POST-EPC MEMORANDUM

RE: Paradise RV Park (formerly West Mesa RV Park)

Project #1008830/11EPC-40073 – Site Development Plan for Building Permit

SP-2

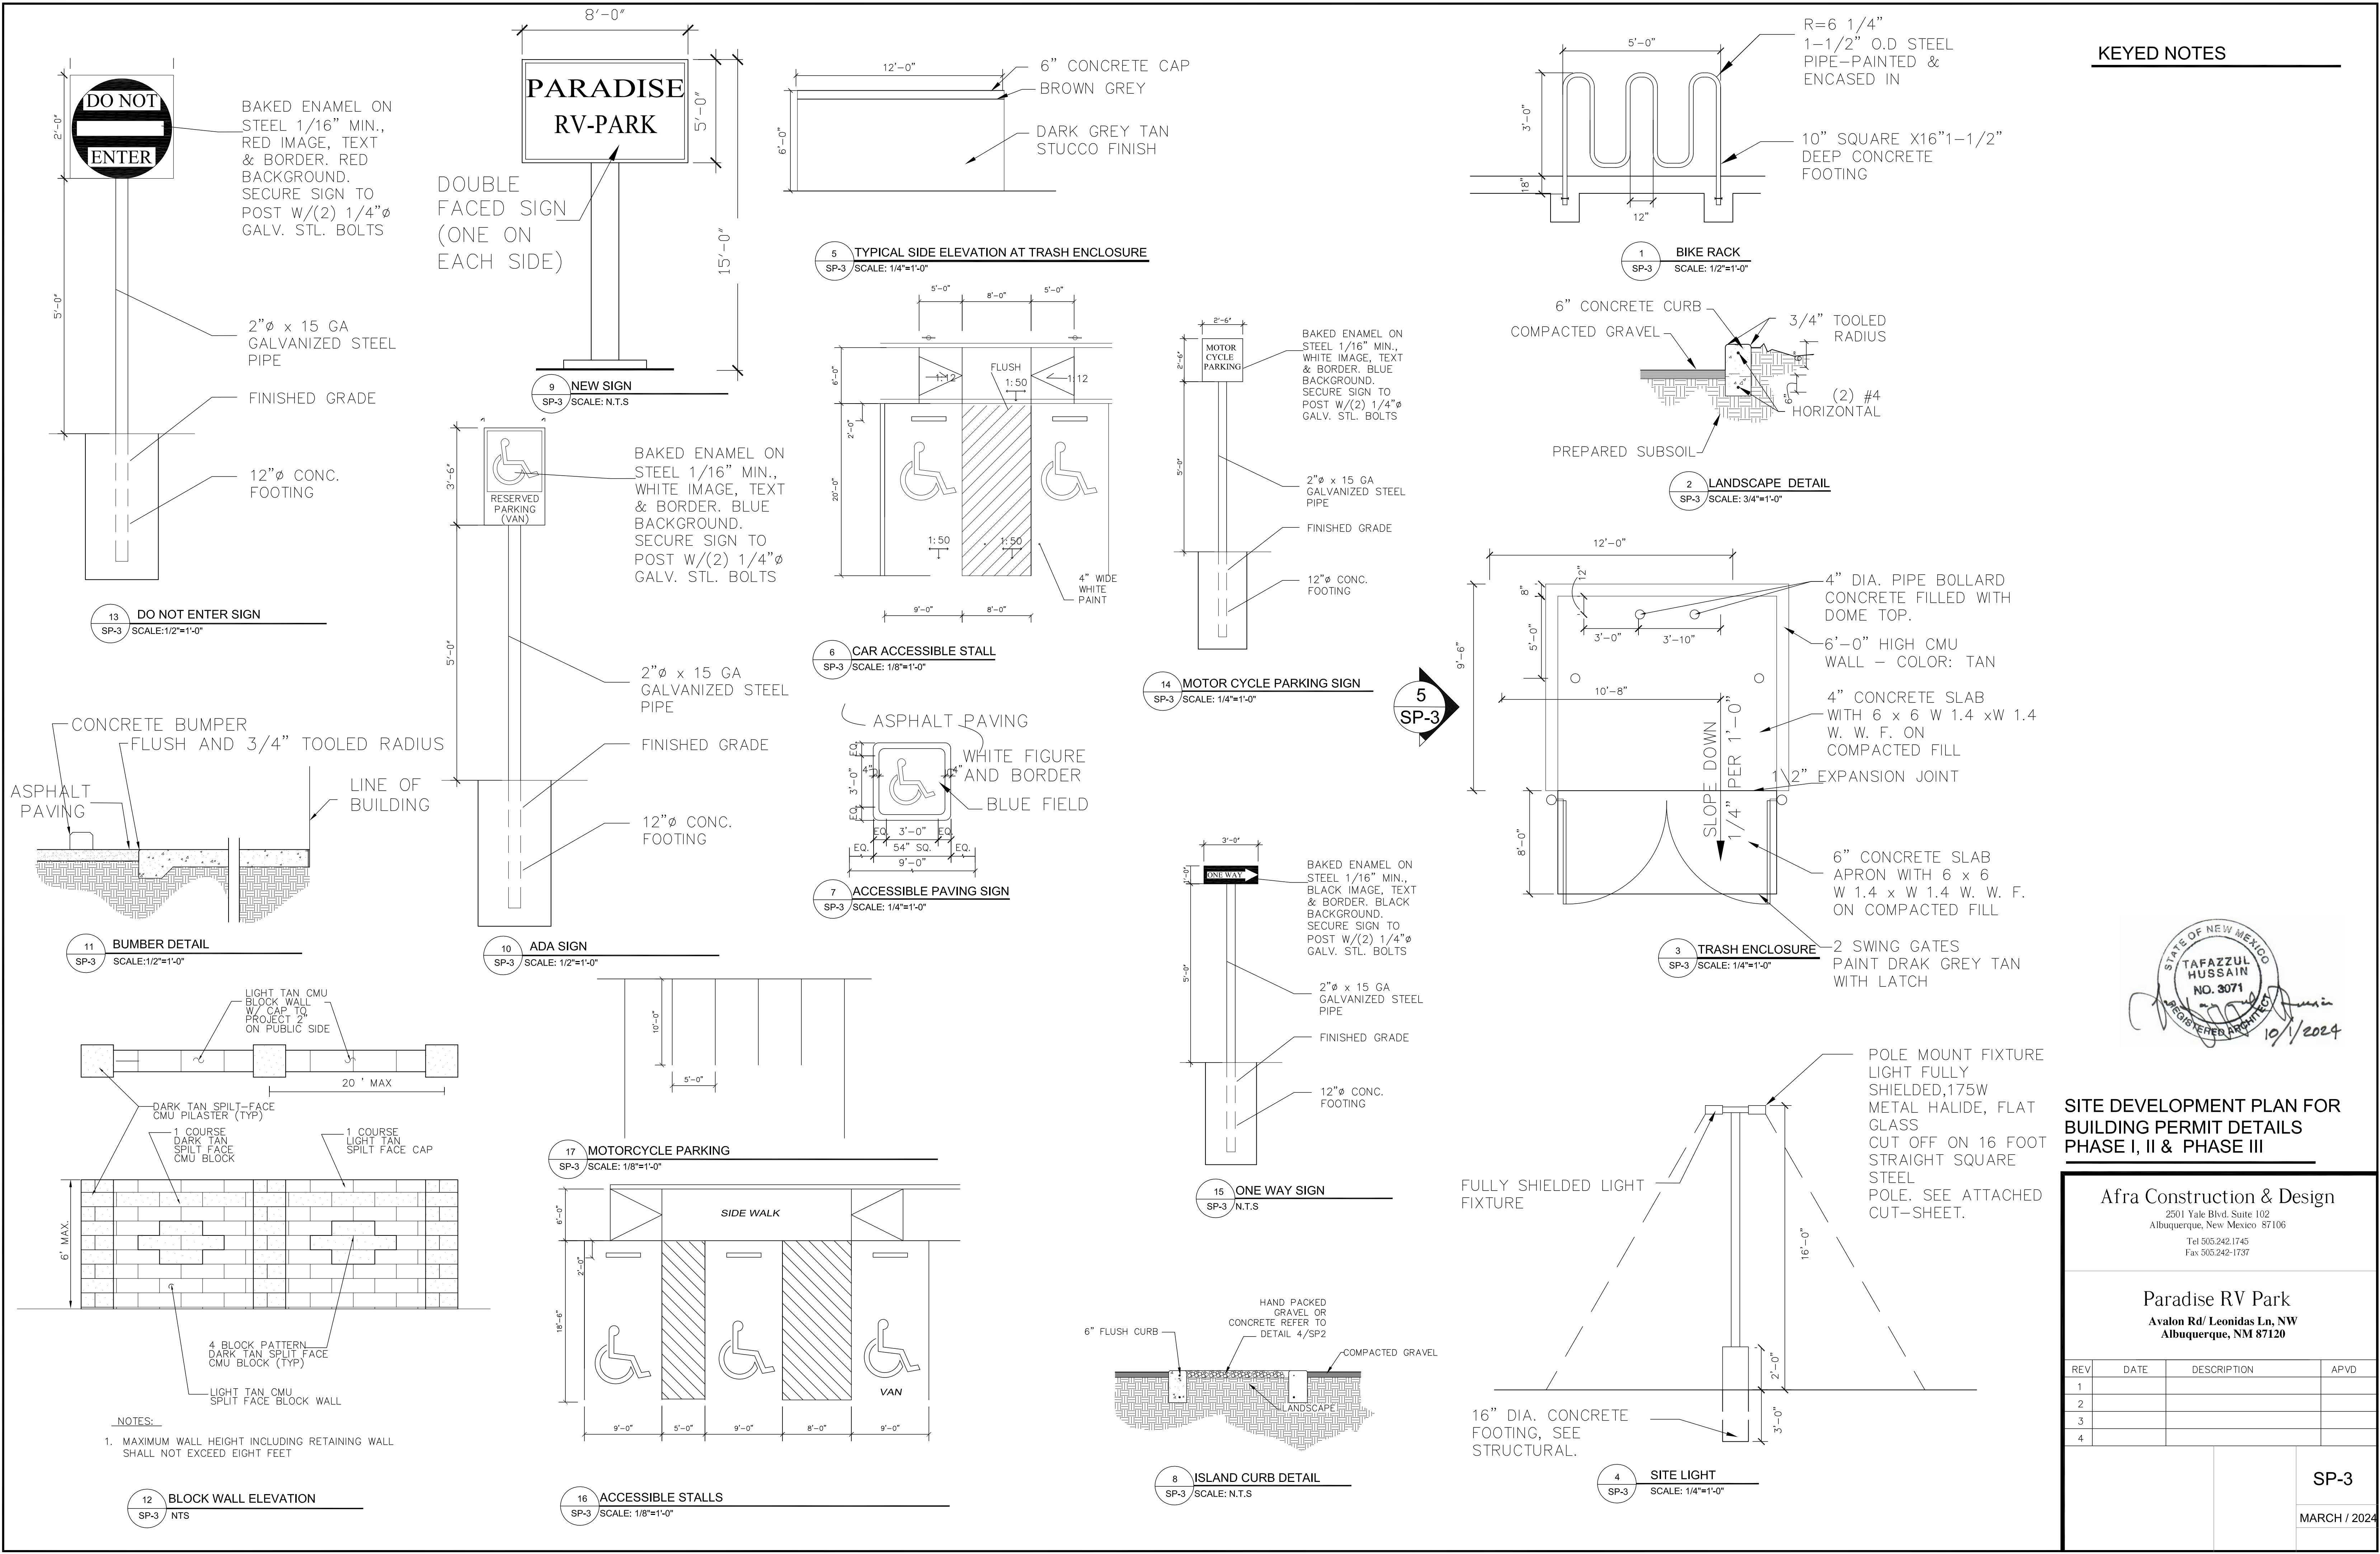
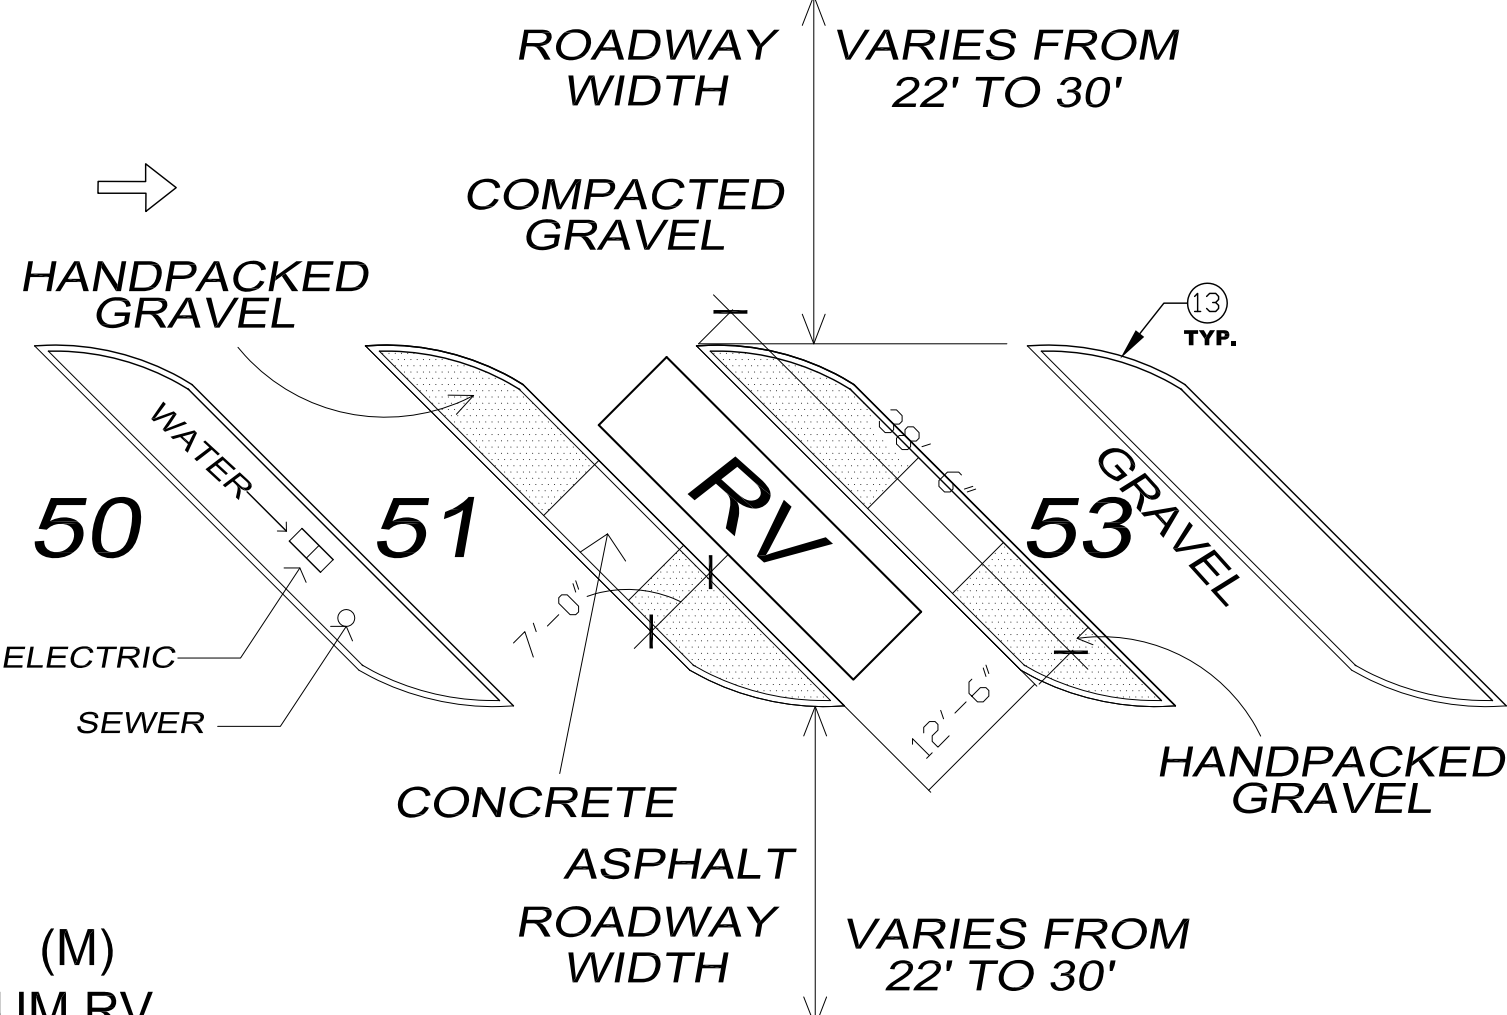
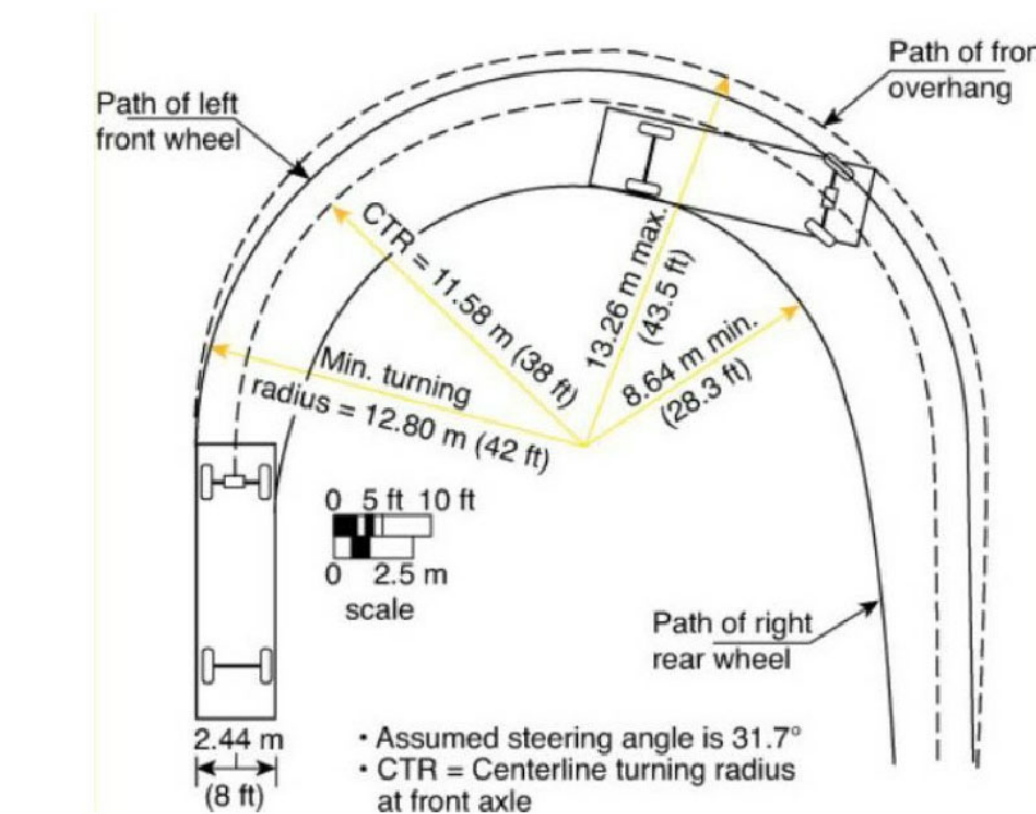
4. Condition 4 has been met. A note indicating the site will comply with Area Lighting Regulations was added to Sheet SP-2.
5. Condition 5 has been met. The quantity of each type of planting and the dimensions of the landscaping beds for Phase II have been provided on Landscape Plan Sheet LS-101. Although Sheet LS-102 is referenced in the post-EPC letter, but it was not submitted with the drawing set. Note that Sheet LS-101 and LS-102 are identical. Please resubmit Sheet LS-102.

7. Condition 7 has been met. Site Development Plan sheet SP-2 Keyed Note #18 states the new pylon sign has two faces. A New Sign double faced sign detail is shown on Sheet SP-3.

- 8a. The 34' wide road access easement is shown on the site development plan Sheets SP-1 and SP-2. The 34' wide road access easement is shown as referenced in Keyed Note #17 on Sheet SP-2.

- 8b. The RV Centerline Turning Radius Template has been added to Sheet SP-2. The proposed RV routes are shown on site development plan Sheet SP-2.
 - 8c. All dimensions are labeled or noted on Sheet SP-2. Proposed road infrastructure Offsite Roadway Sections have been added to Sheet C-03.

- 8d. ADA Car Accessible Stall Details have been added to Sheet SP-3. ADA accessible pathways from parking stalls to building are shown on Sheet SP-2.

- 8e. A 6' wide ADA accessible pathway from the roadway to the building is noted and shown on Sheet SP-2 and referenced in Keyed Note #19.
 - 8f. Limits of Pavement are shown on the Typical Offsite Roadway Sections on Sheet C-03. The cross sections note the limits of the paving to be conducted on Volcano Rd NW, 102nd St, and Avalon Rd.

- 8g. Leonidas Lane is noted on Site Plan sheet SP-2 as a 50' Private Access Easement with a reference to the recording information.
 - 8h. Paving markings of arrows and notation showing ONE WAY and TWO WAY traffic are shown on Site Development Plan Sheet SP-2. Detail Sheet SP-3 shows the One Way Sign detail.

- 8i. Access Easements are labeled and shown on Site Development Plan Sheets SP-1 and SP-2.
 - 8j. An Infrastructure List with all offsite improvements have been provided by the applicant.
